D2015/123097

**Water NSW submission on State Significant Development Application for the Staged Commercial Precinct at 185-195 Fifteenth Avenue, West Hoxton (SSD 6407)**

Water NSW has reviewed the SSD Application and provides the following comments:

DESIGNED DRAWN DATE CHECKED SIZE SCALE CAD REF:
 B1 AS SHOWN Cst11995.000A20

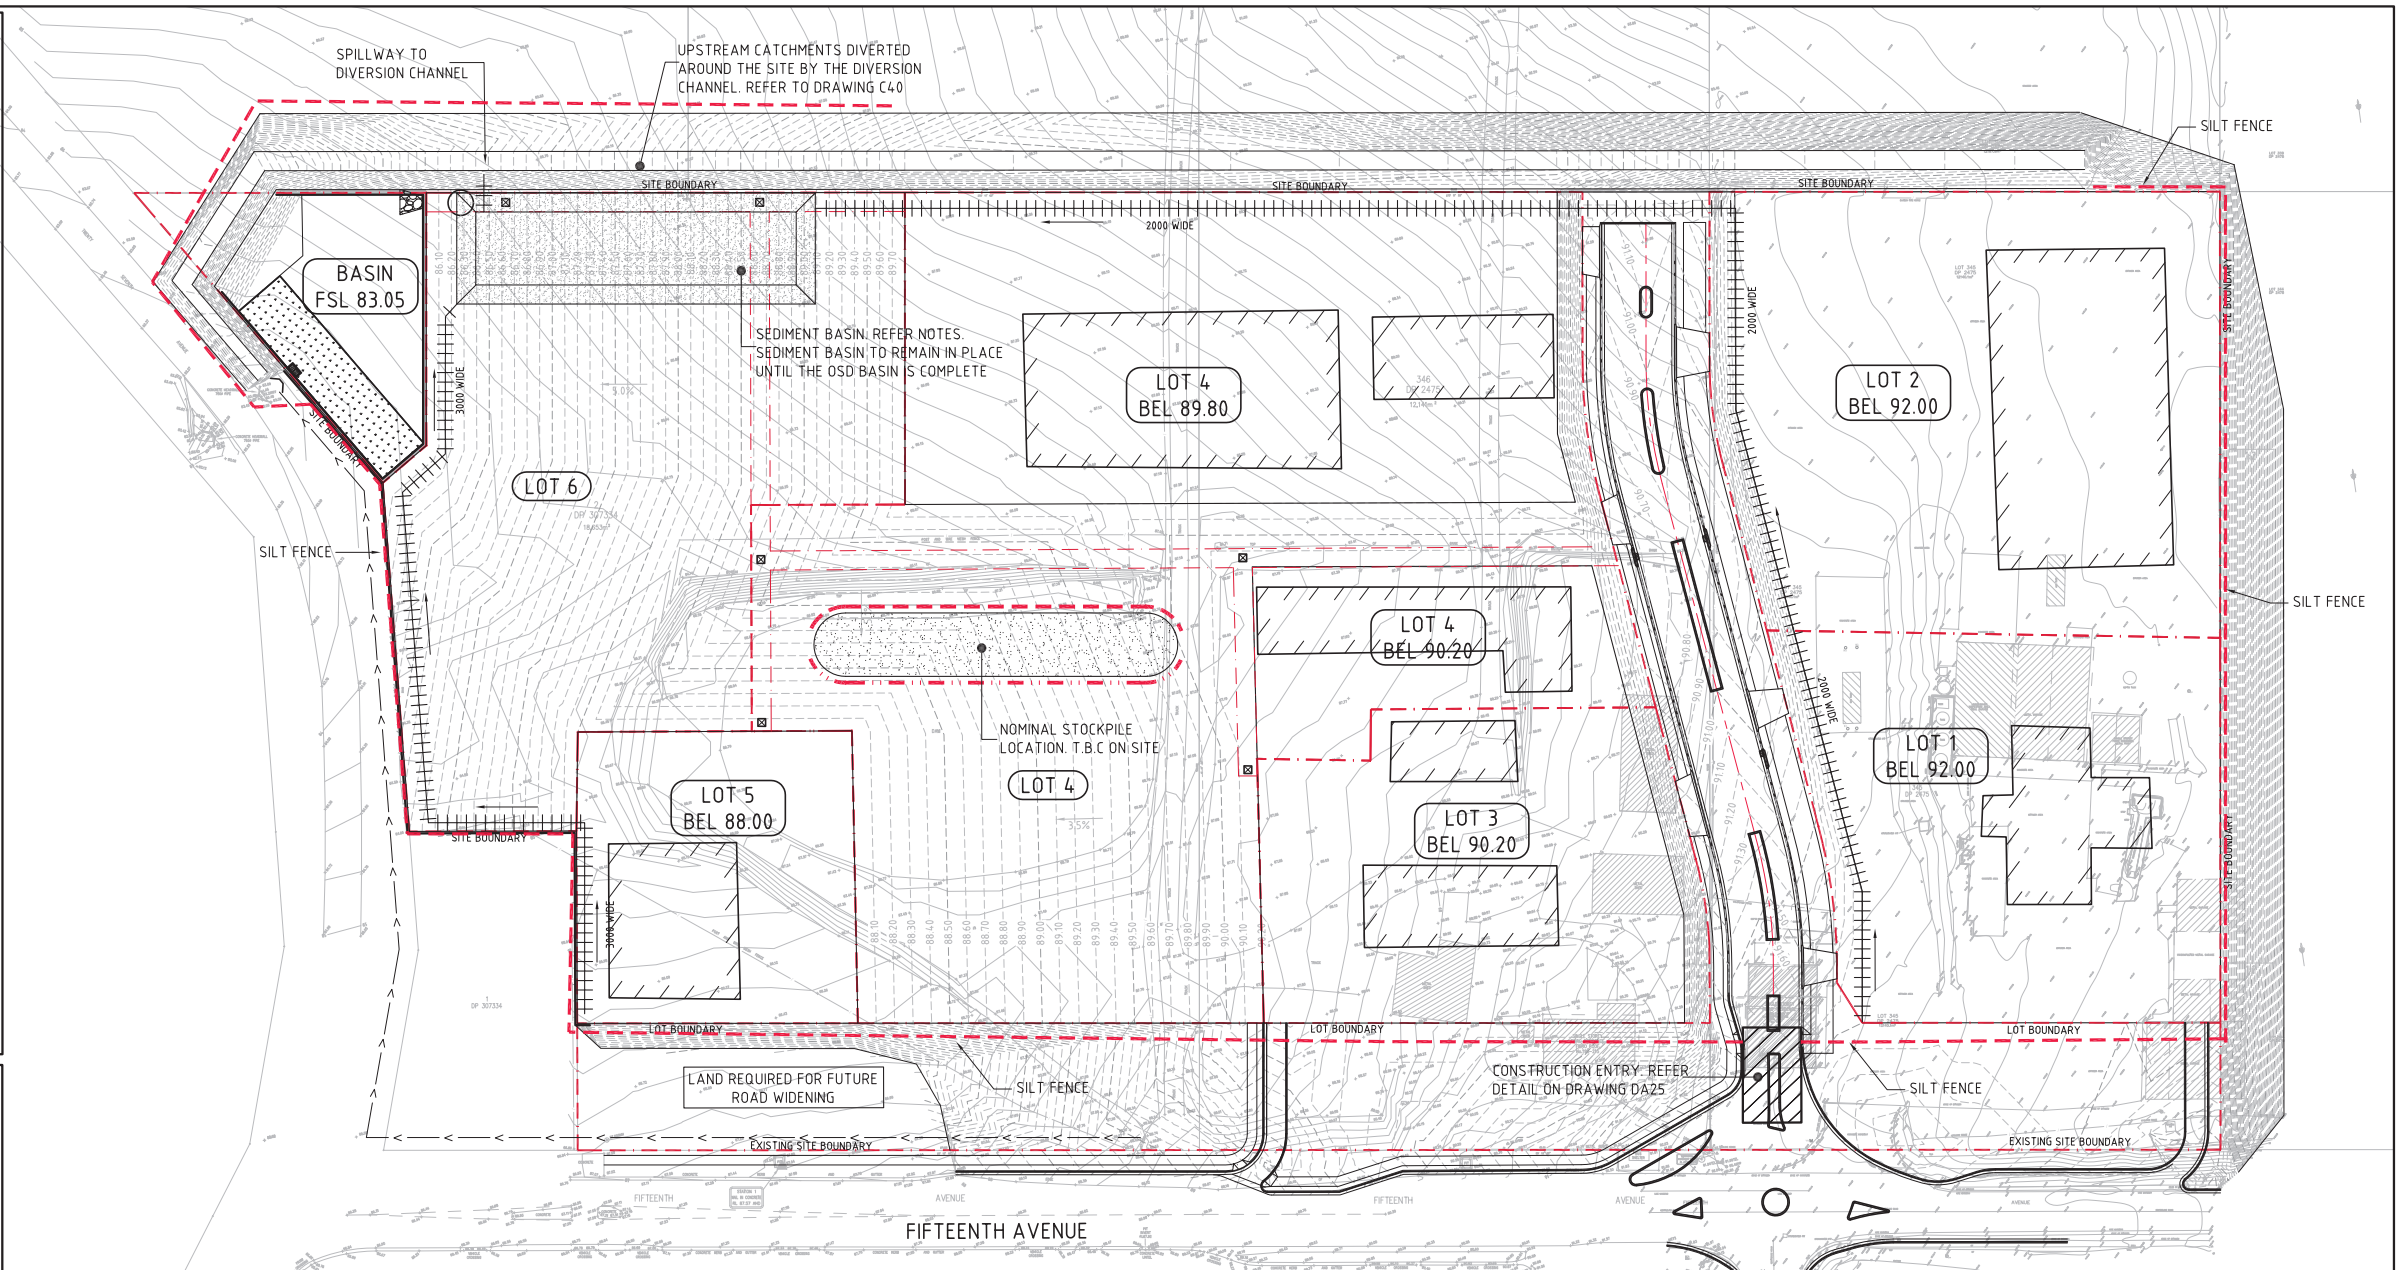
- 2.1 *Effective erosion and sediment controls shall be installed prior to any construction activity, including bulk earthworks, and shall prevent sediment or polluted water from entering the Upper Canal corridor and Upper Canal, as per the Erosion and Sediment Control Plan (Dwg No. CO11995.00-DA20; Iss D; dated 19 June 2015) and Erosion and Sediment Control Details (Dwg No. CO11995.00-DA25; Iss D; dated 19 June 201), both prepared by*

*Costin Roe Consulting Pty Ltd. The controls shall be regularly maintained and retained until works have been completed and the ground surface stabilised or groundcover re-established.*

DRAWING No. **C011995.00- DA30** ISSUE **D**

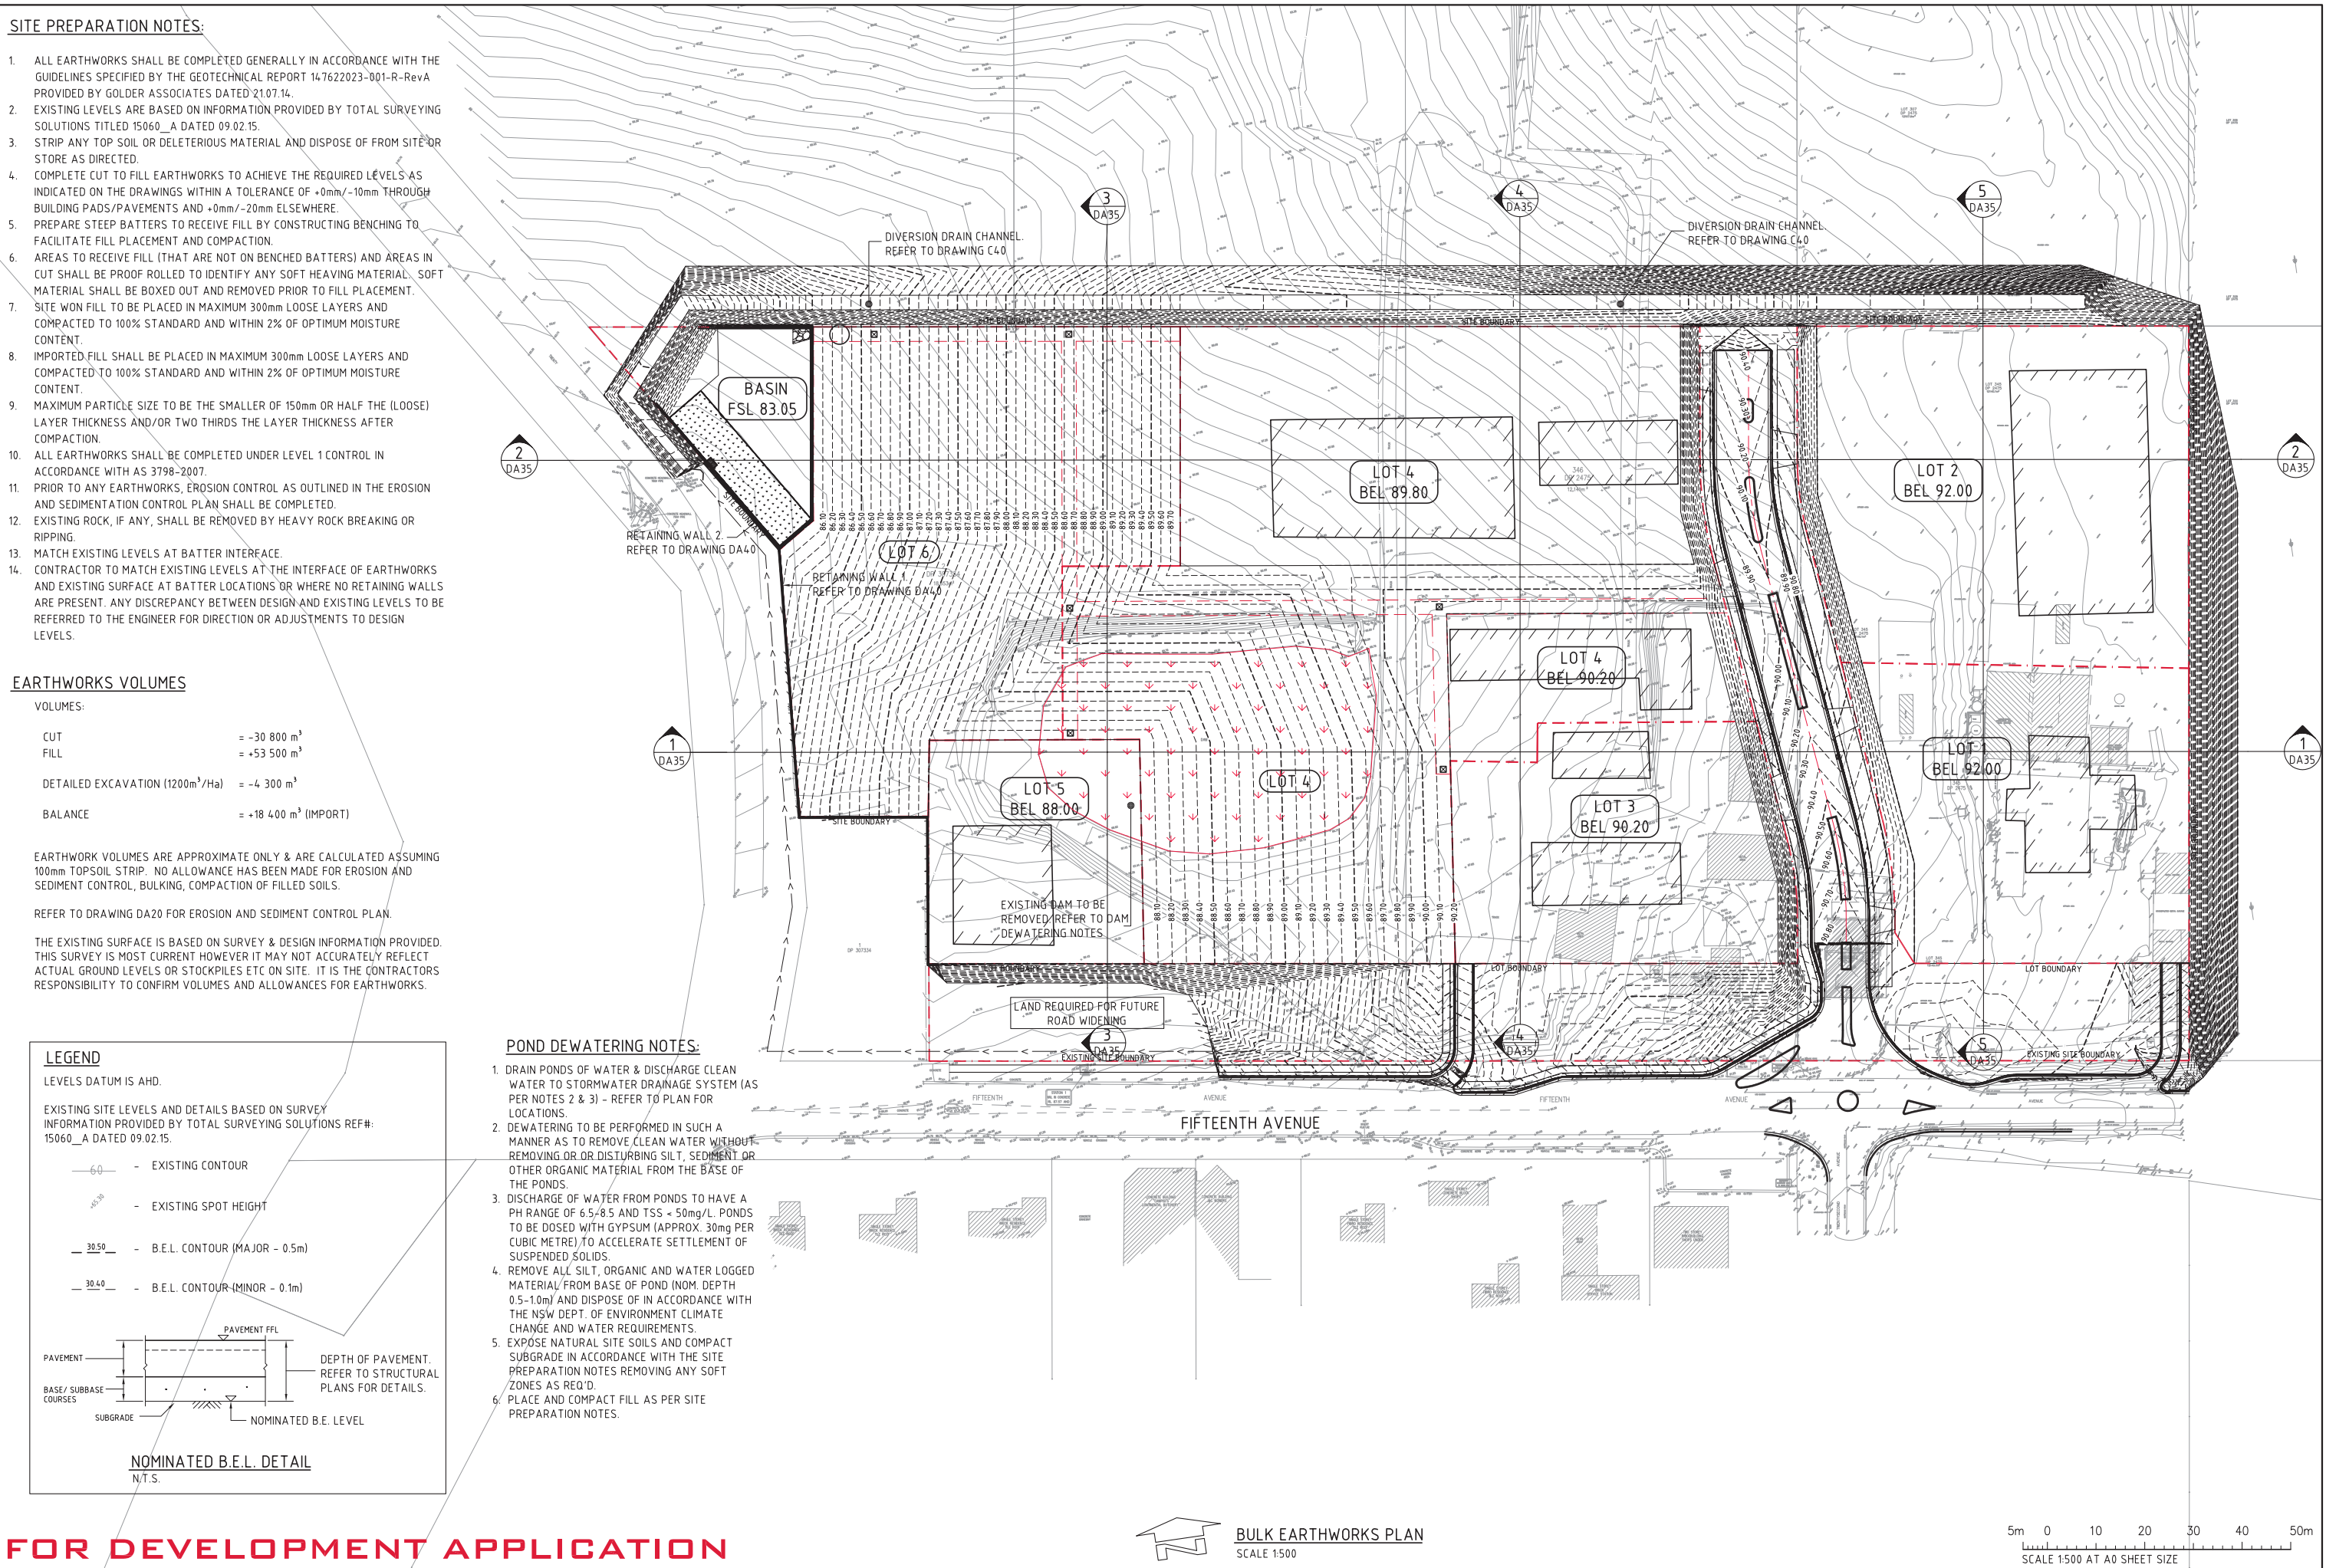
- 1.4 *There shall be no modification to any existing stormwater structure within the Upper Canal corridor without the prior agreement of Water NSW.*
- 1.5 *Dewatering of the existing dam on Lot 2 DP 307334 shall be undertaken as per the Bulk Earthworks Plan (Dwg No. CO11995.00-DA30; Iss D; dated 19 June 2015) prepared by Costin Roe Consulting Pty Ltd, and shall ensure that no discharge from the dam is directed into the Upper Canal corridor and shall comply with Conditions 1.1 and 1.2 above.*
